KU-RING-GAI COUNCIL SUBMISSION

**MP 08 0207 - Concept Plan and
MP 10 0219 - Project Application**

Preferred Project Report

1, 1A, 5 Avon Road, 4 & 8 Beechworth Road Pymble

01 SECTION A/A

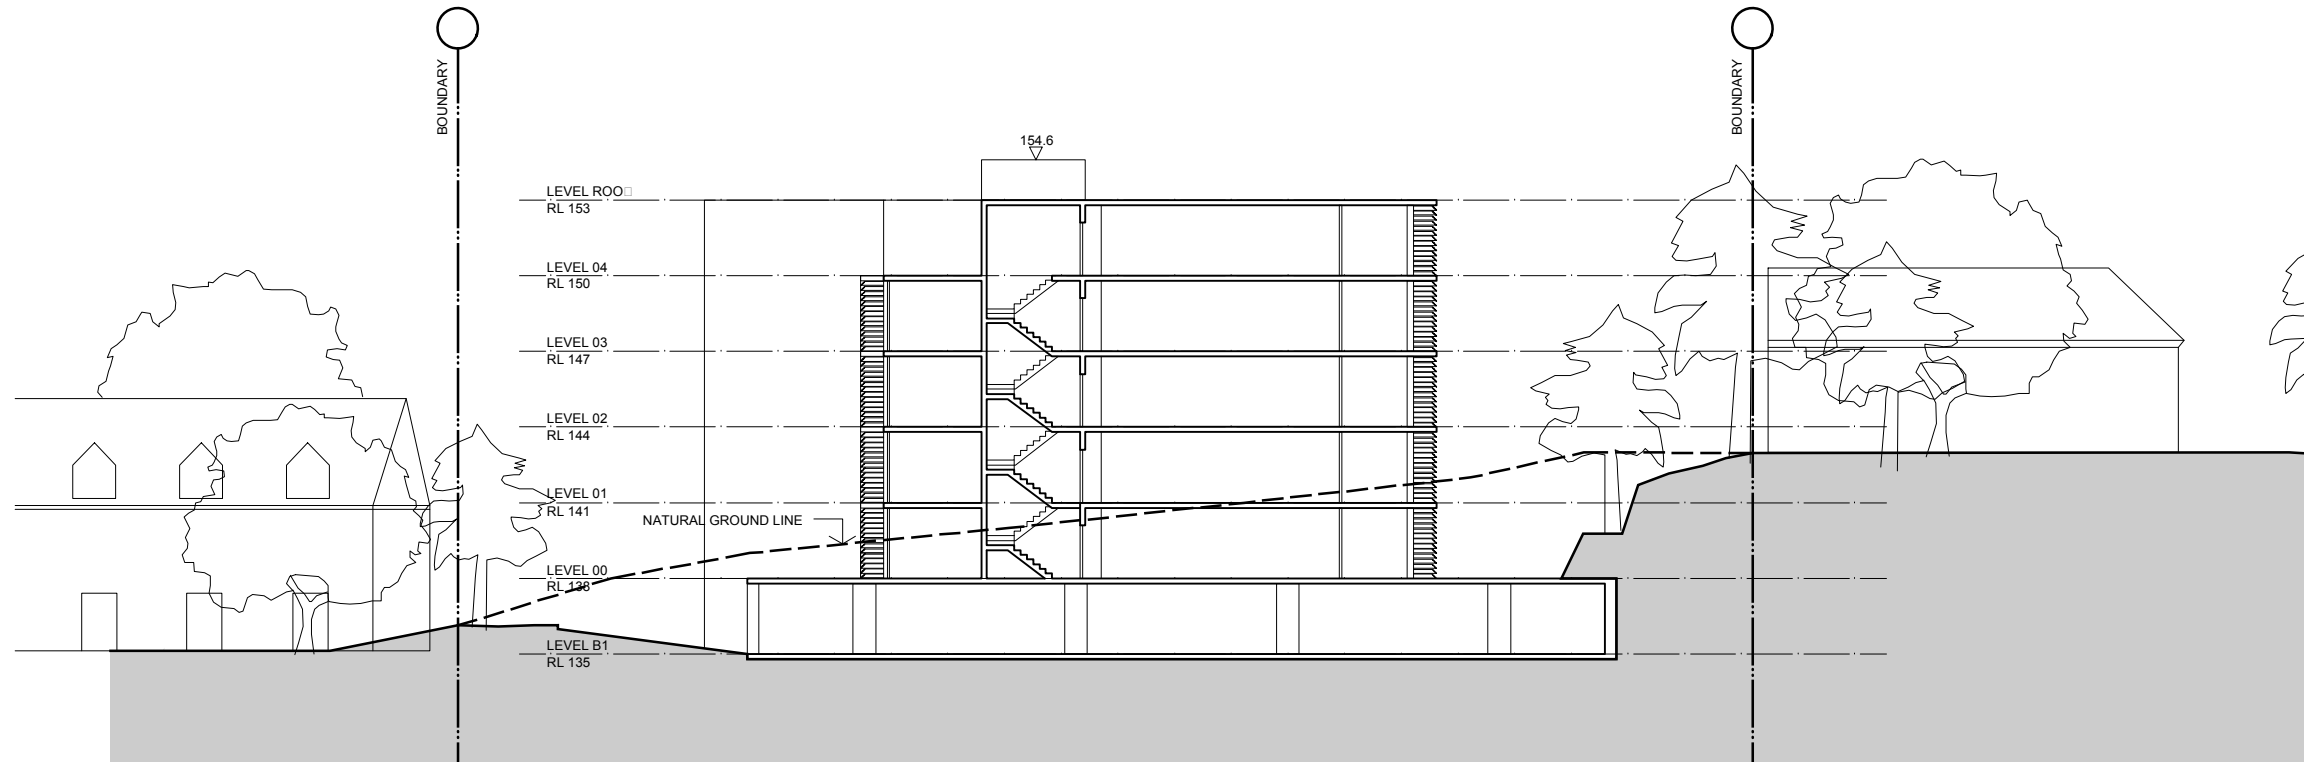
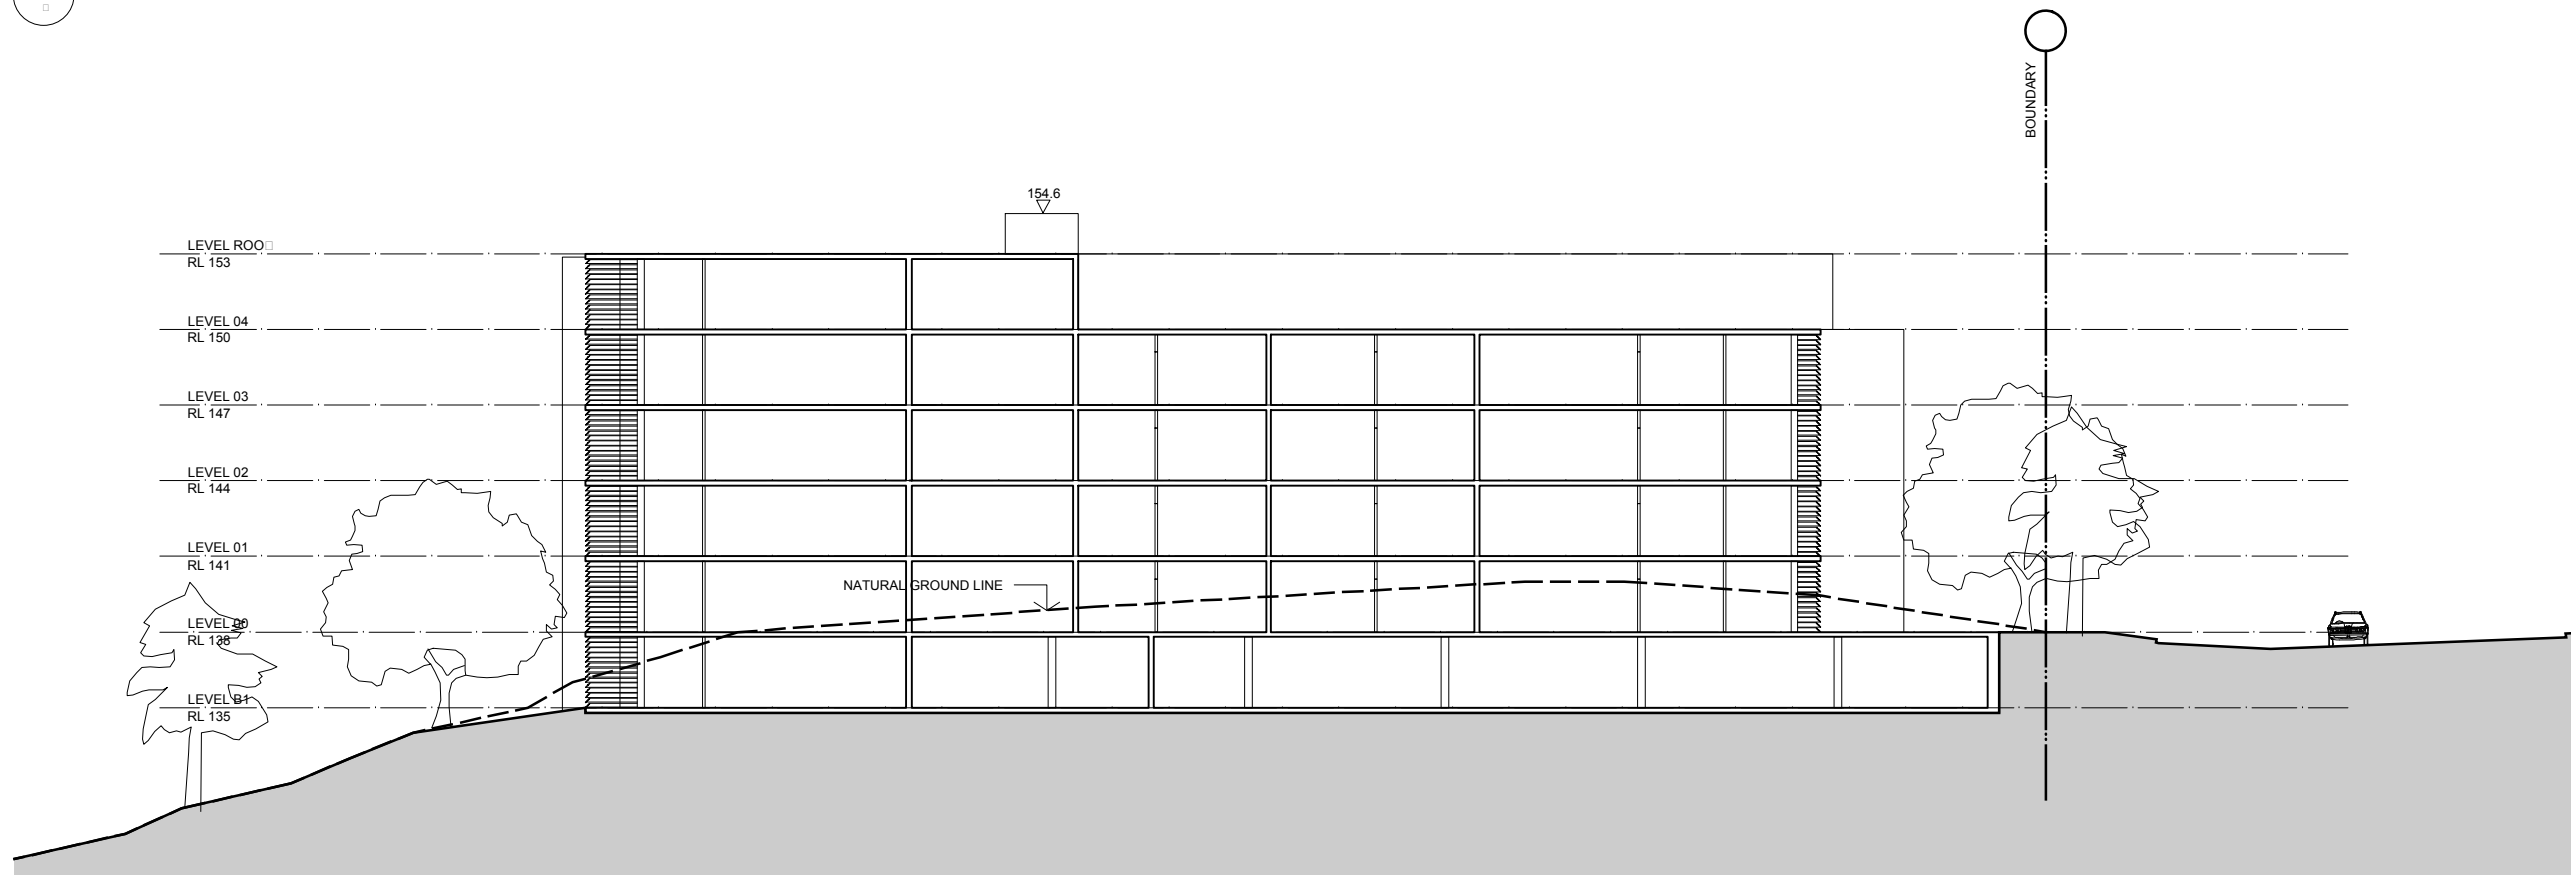
- The plan drawings MP02.01 through MP02.06, which are put forward for the approval of building envelopes, incorrectly document the neighbouring properties when compared to the site survey. These plan drawings also appear to have been used to generate, incorrectly, the 'indicative elevation plans of each of the Concept Plan envelopes' (MP03.01 through MP04.04) and 'dimensioned cross section plans' (MP02.07 and MP02.08) as required by Schedule 2 of the DPI 2011.

- Inadequate information has been provided to determine the height of the buildings, as defined by KLEP (Local Centres) 2012. An RL for existing ground level is required to be shown on the elevations/sections.
